Historic England

Our ref: L01598575

10 October 2025

**BLAKES COTTAGE 1 BLAKES ROAD FELPHAM PO22 7EB  
Application Nos FP/130/25/L & FP/129/25/HH**

| 2302-01/01/203 | - |

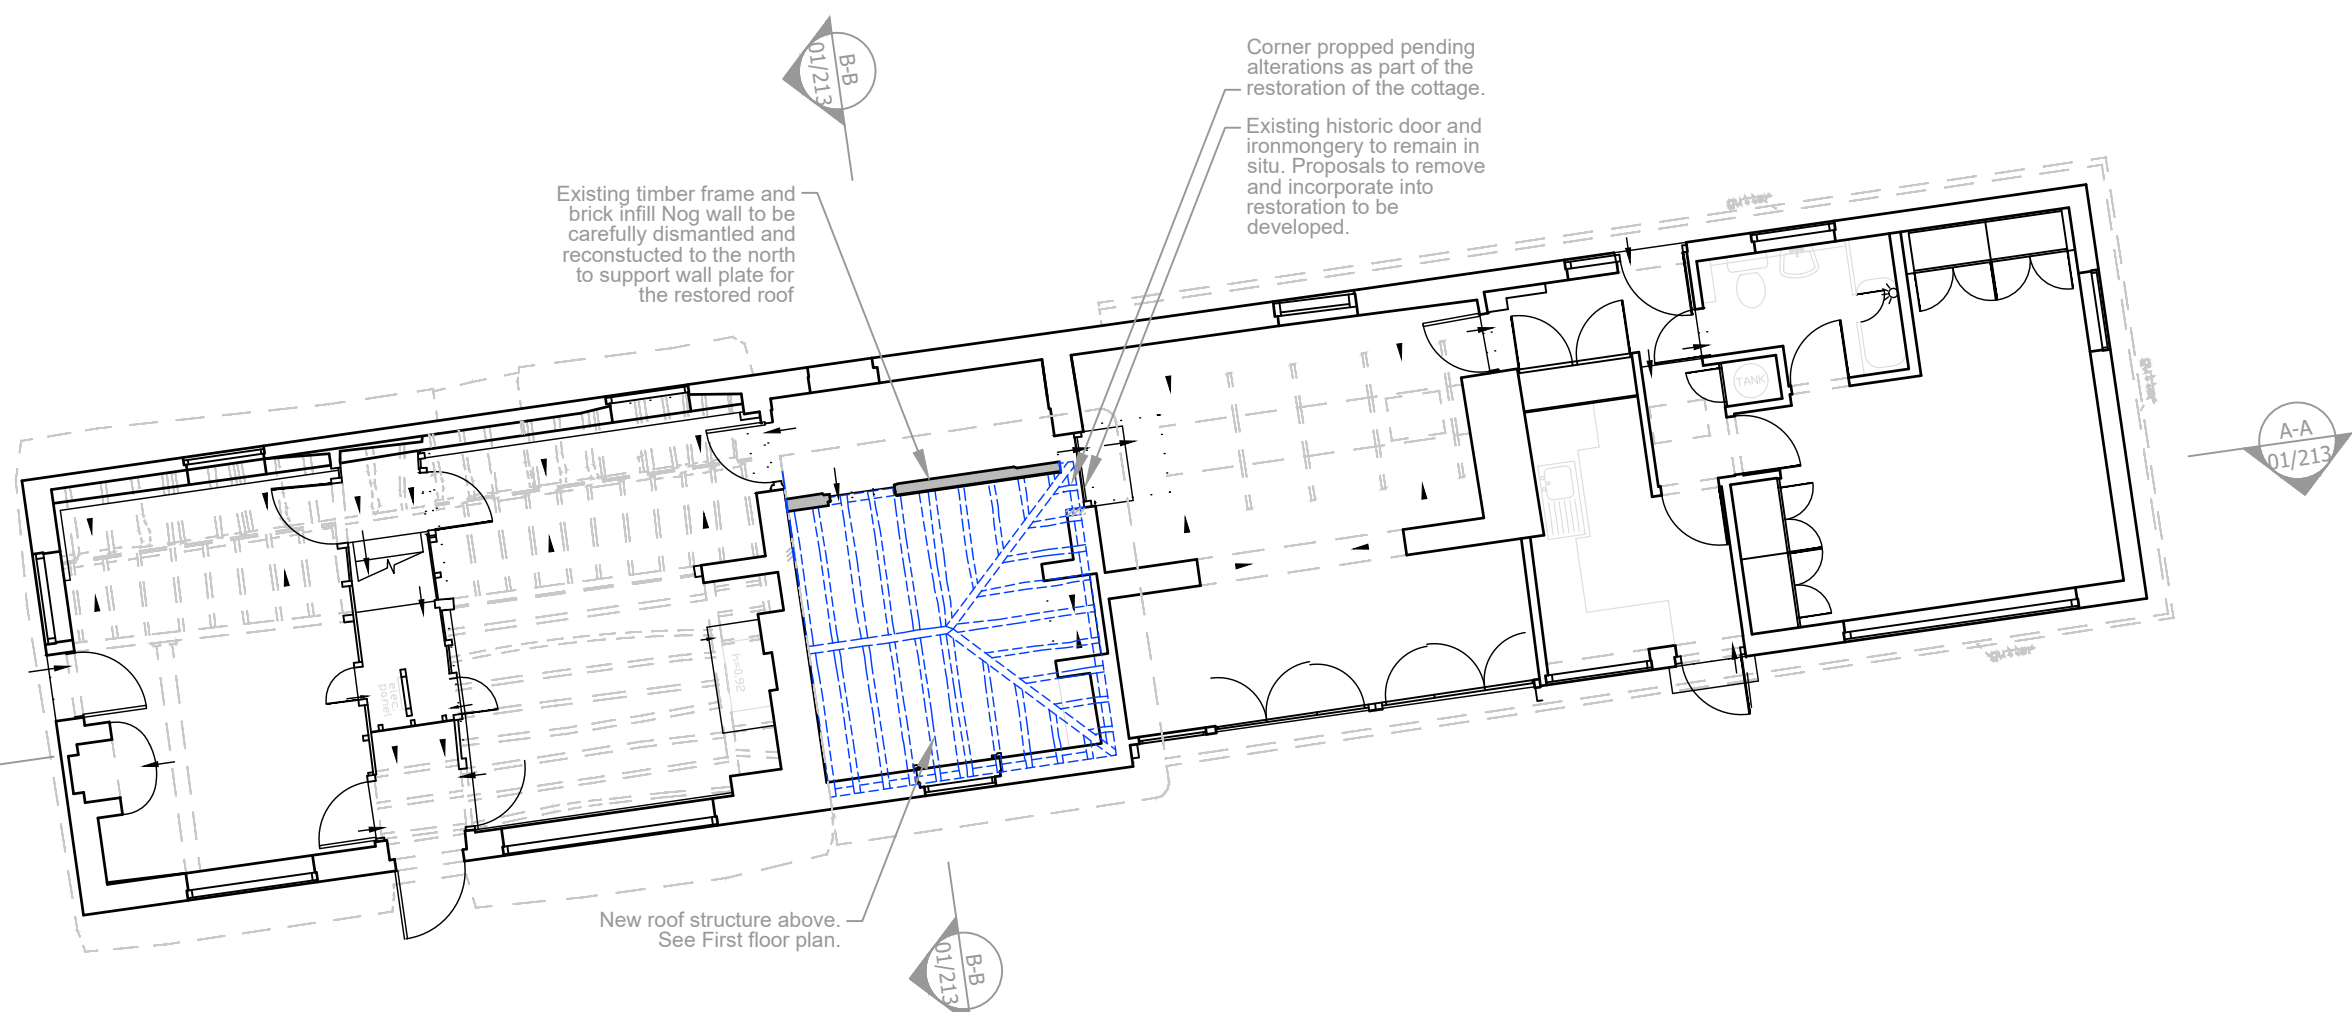
In this respect, we note that the proposed external north wall to the reconstructed eastern single storey element would need to be entirely rebuilt along with new foundations, as currently this is an internal wall.

We think there is a lack of detail contained within the submissions with regards to the appearance and how this wall would be constructed, including its foundations. We therefore recommend this is controlled by condition requiring the submission of details of the appearance, methods and materials for the proposed reconstruction of this north wall and its foundations.

- submission and approval of further details for the appearance, methods and materials for the reconstruction of north wall and its foundations of the proposed eastern single storey element; and
- sample panels provided and approved for any flint work wall reconstruction and samples of the proposed new windows.
